Application number: 2026/91547	
What is the application for?:	Change of use of residential dwelling (Use Class C3) to childrens care home for
Address of the site or building:	28, Sylvan Ridge, Huddersfield, HD2 1ZH
Postcode:	HD2 1ZH

BLOCK PLAN

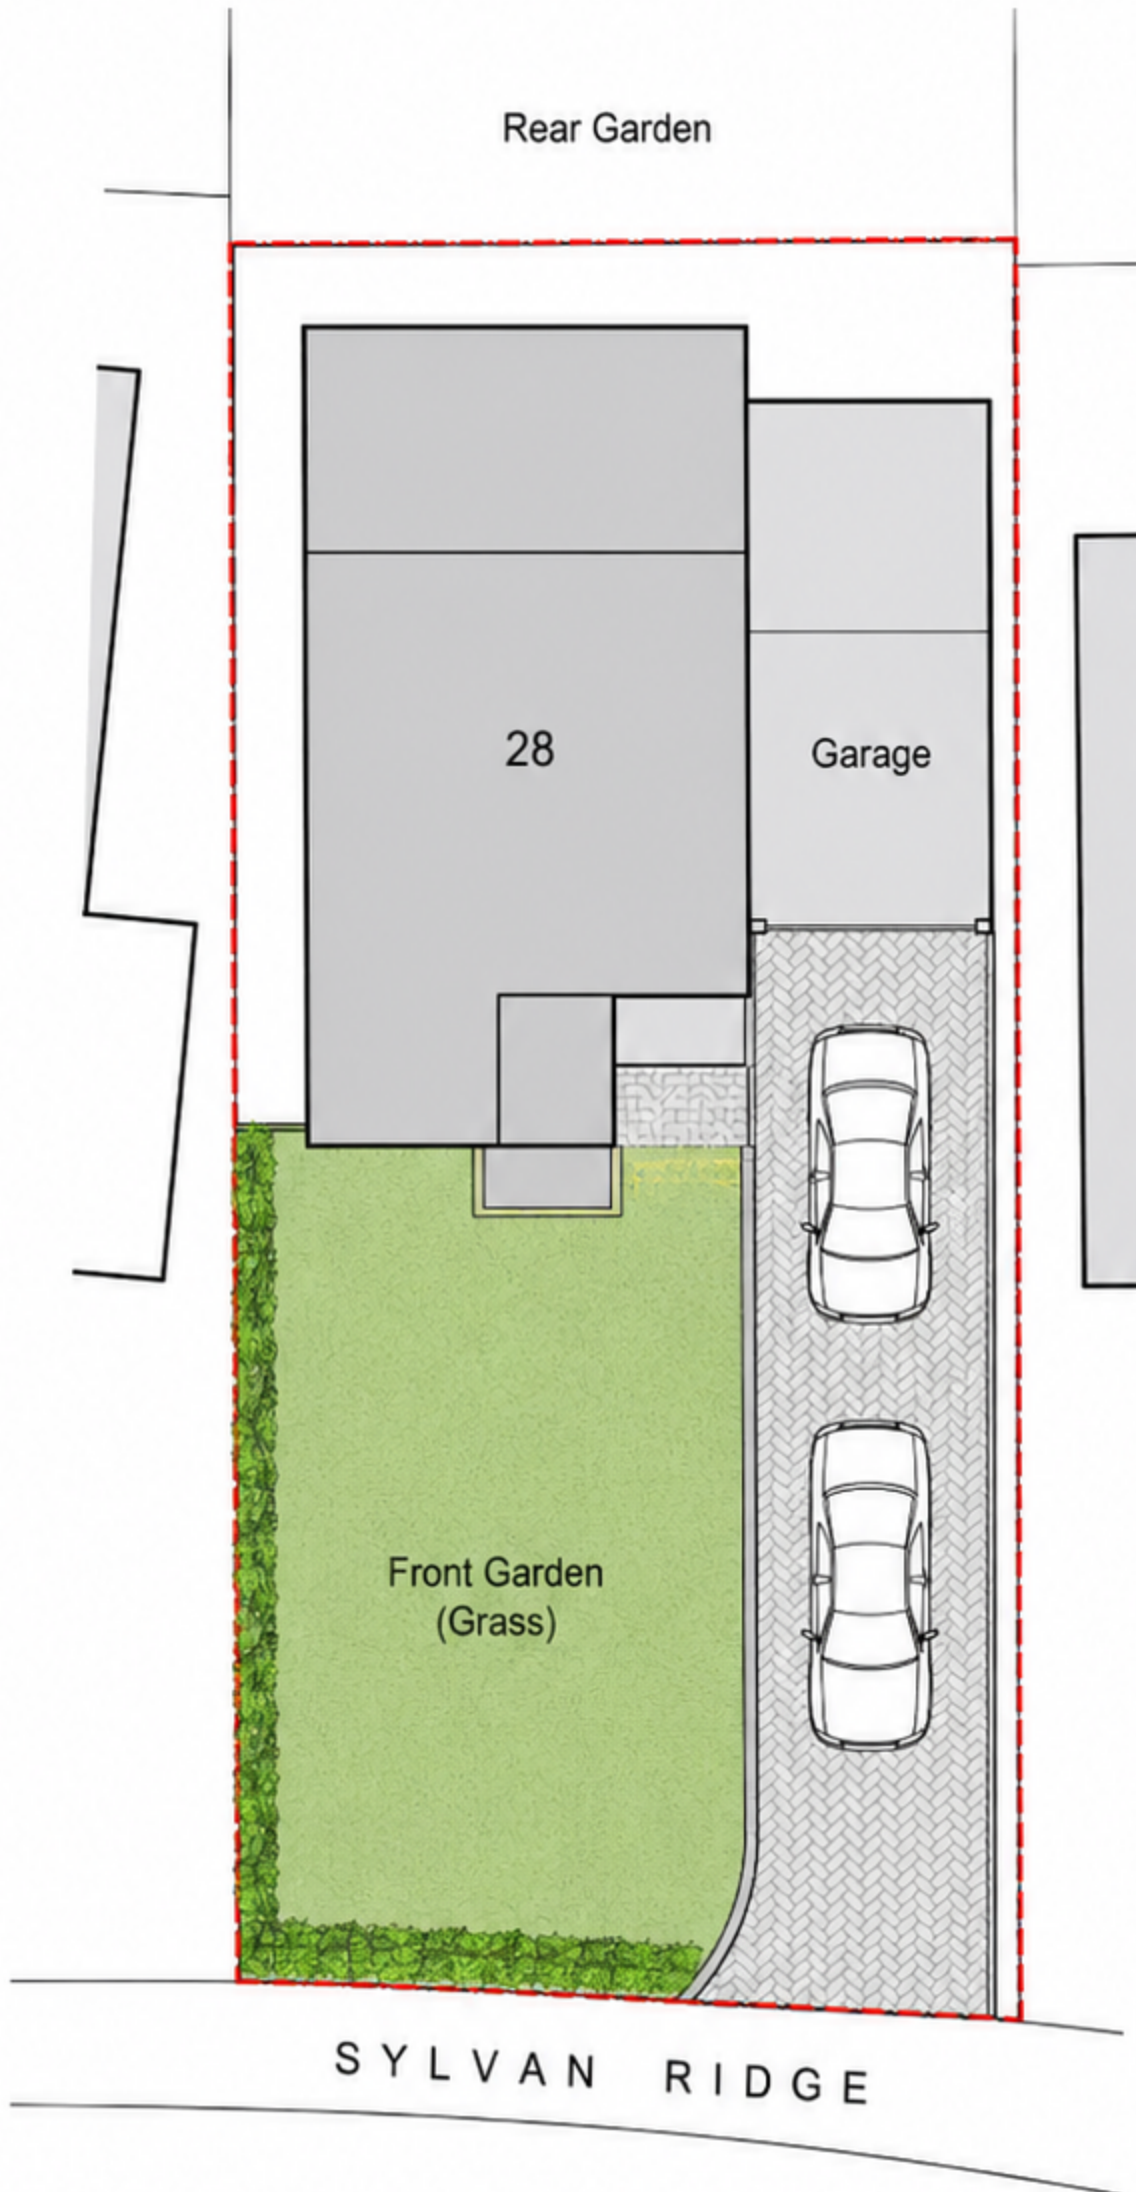
Type of comment: An objection	
Do you wish your comments to be published on the website anonymously?	Yes
Further to previous objection submitted, I wish to also highlight that the block plan for the property not only misrepresents the layout of the garden and the fact that there is an adjoining drive and garage with the neighbour but also the small location map embedded in the block plan doesn't match that of the location plan map which is separately submitted. The mini map embedded in the block plan doesn't represent the street at all and is misleading. I wish for this observation to also be duly noted in terms of objection.
